CITY OF ALBUQUERQUE

April 2, 2012

**Re: Broadstone Santa Monica Place
Grading and Drainage Plan
Engineer's Stamp dated 3-7-2012 (D18/D054)**

OVERALL
GRADING AND DRAINAGE PLAN

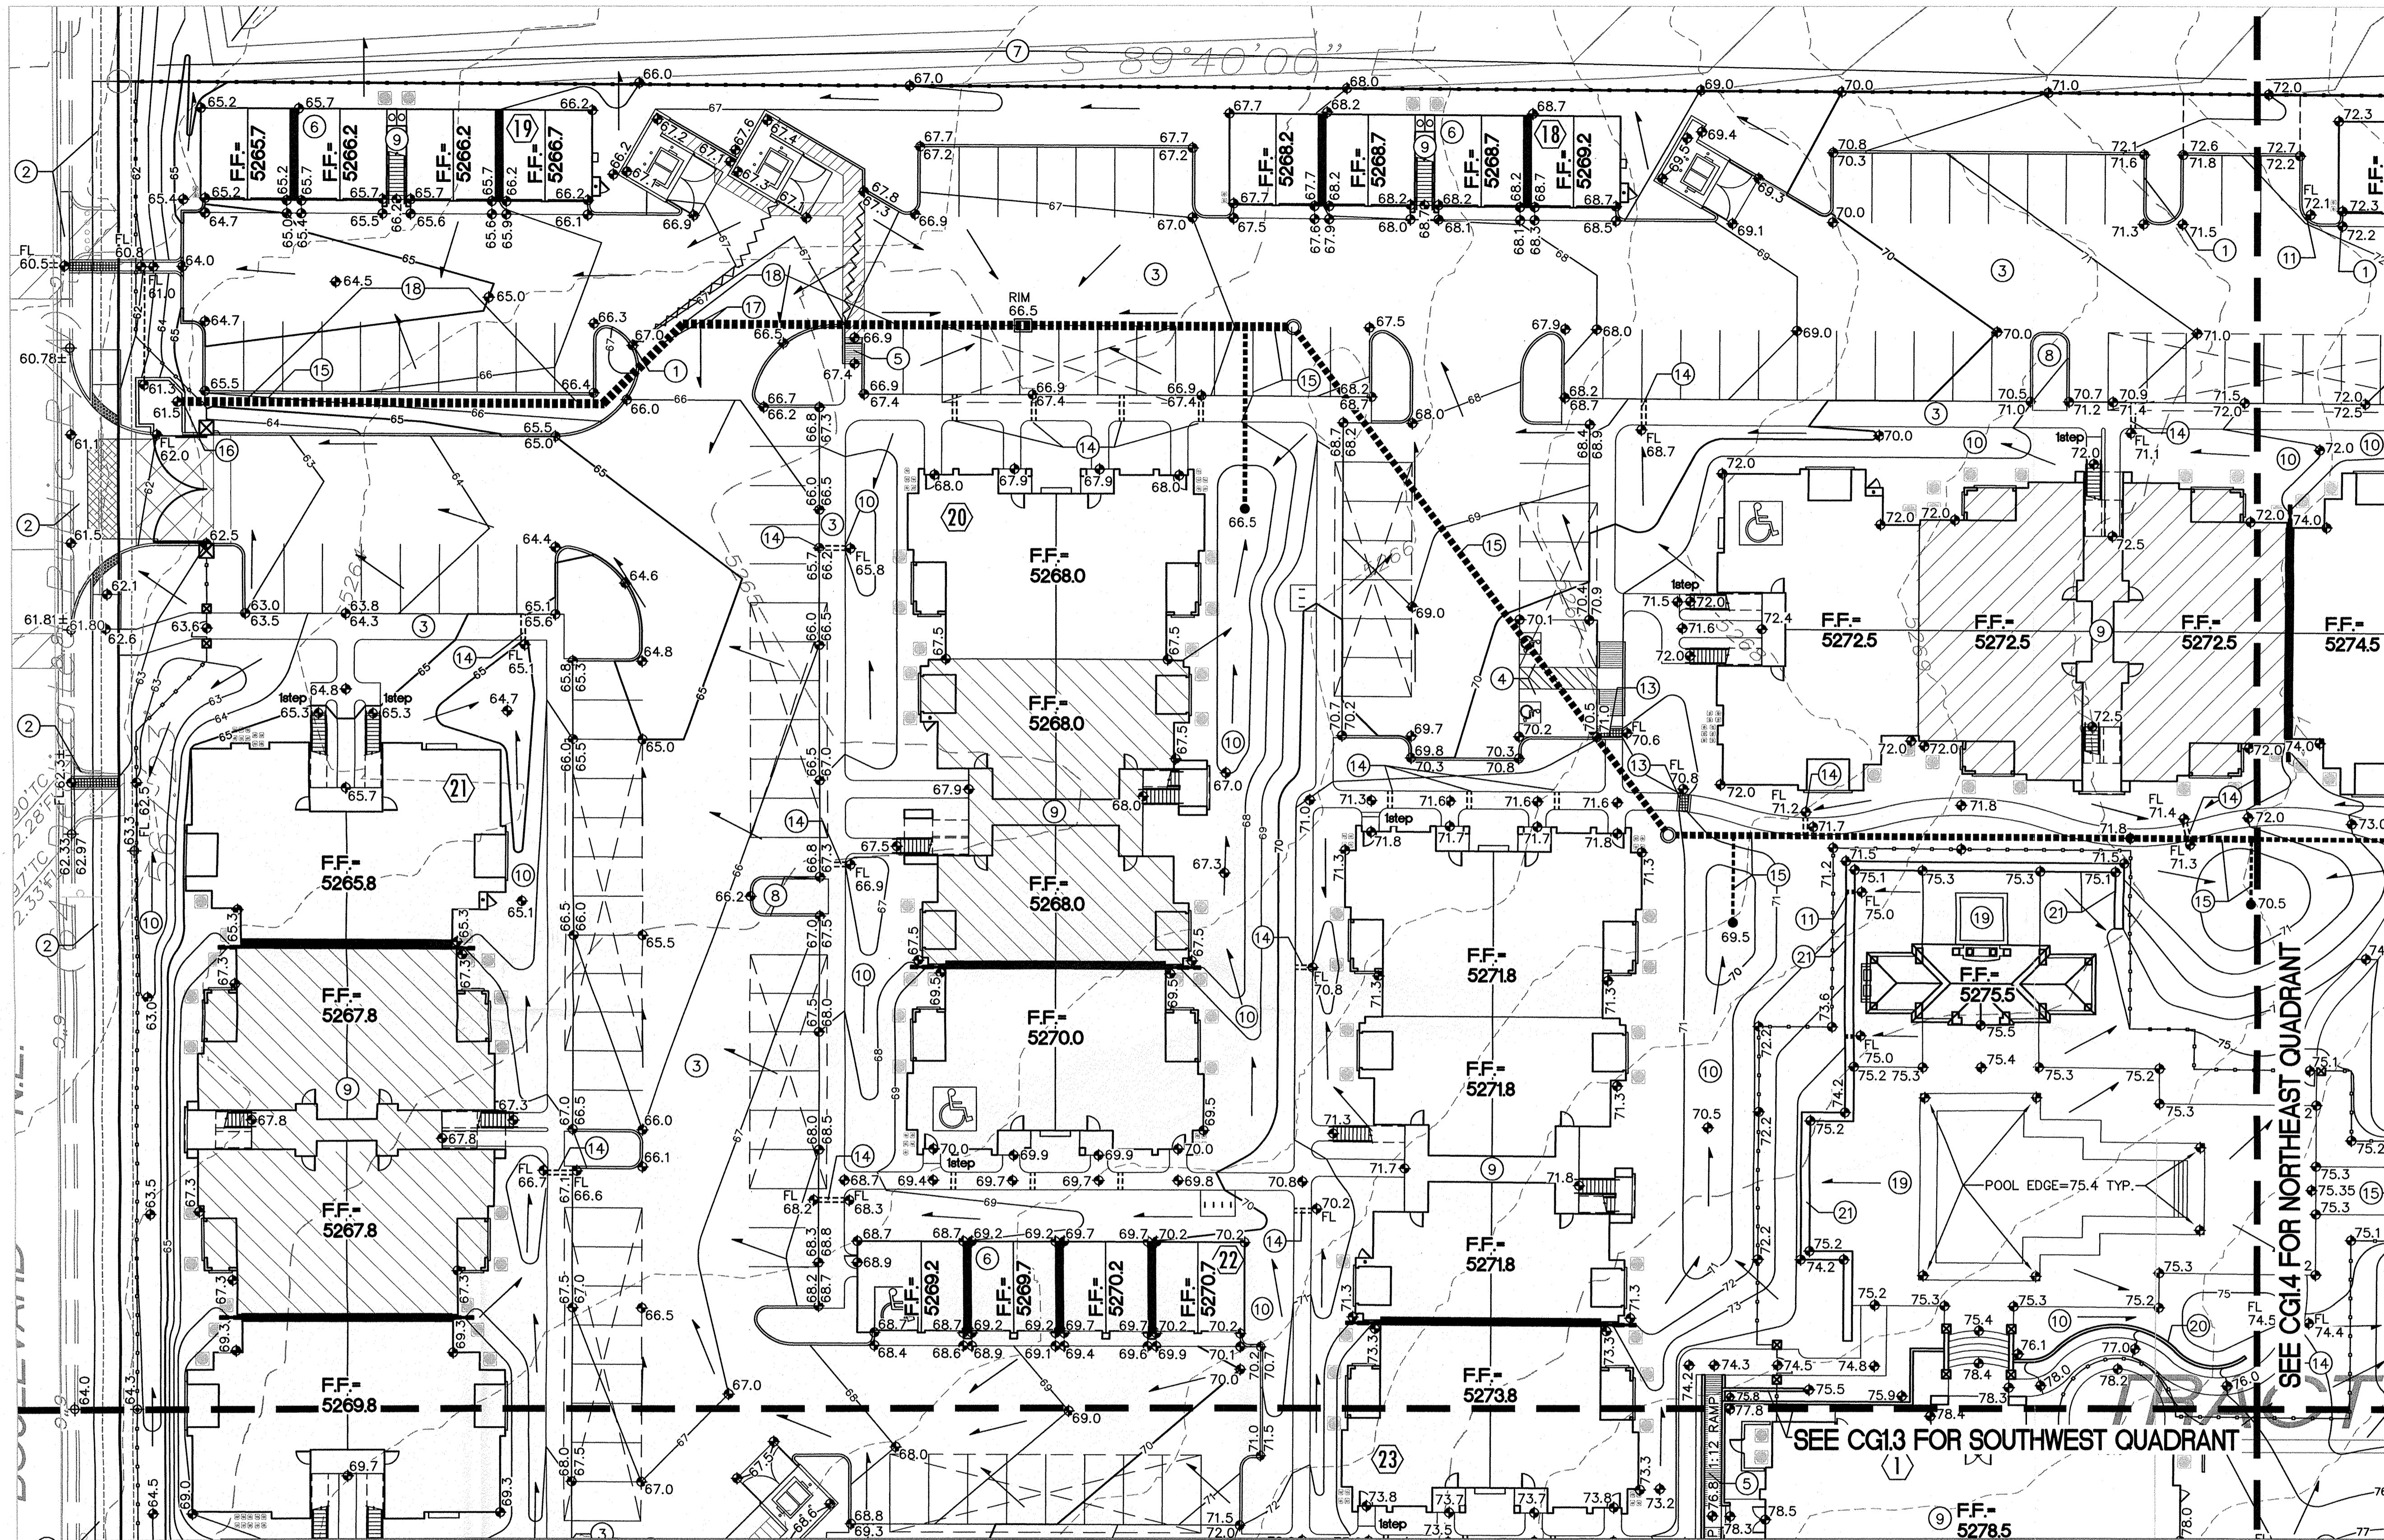
- Pond calculations are needed for the small pond just north of the entrance/exit on San Pedro. What is the WSE?
- How are the proposed contours tying in with the contours to the north of this site at the NW corner?
- Provide the direction of roof flows for the units in the NW corner. These flows should not drain over the sidewalk.
- Are all landscape areas being depressed as well as the areas with sidewalk culverts? Can the small islands in the parking lots contain a 1' cut in the curb to accept flows? This would assist in lowering the flows entering San Pedro for the first 6 hours and would also help with the new EPA regulations and the MS 4 permit coming in the near future.
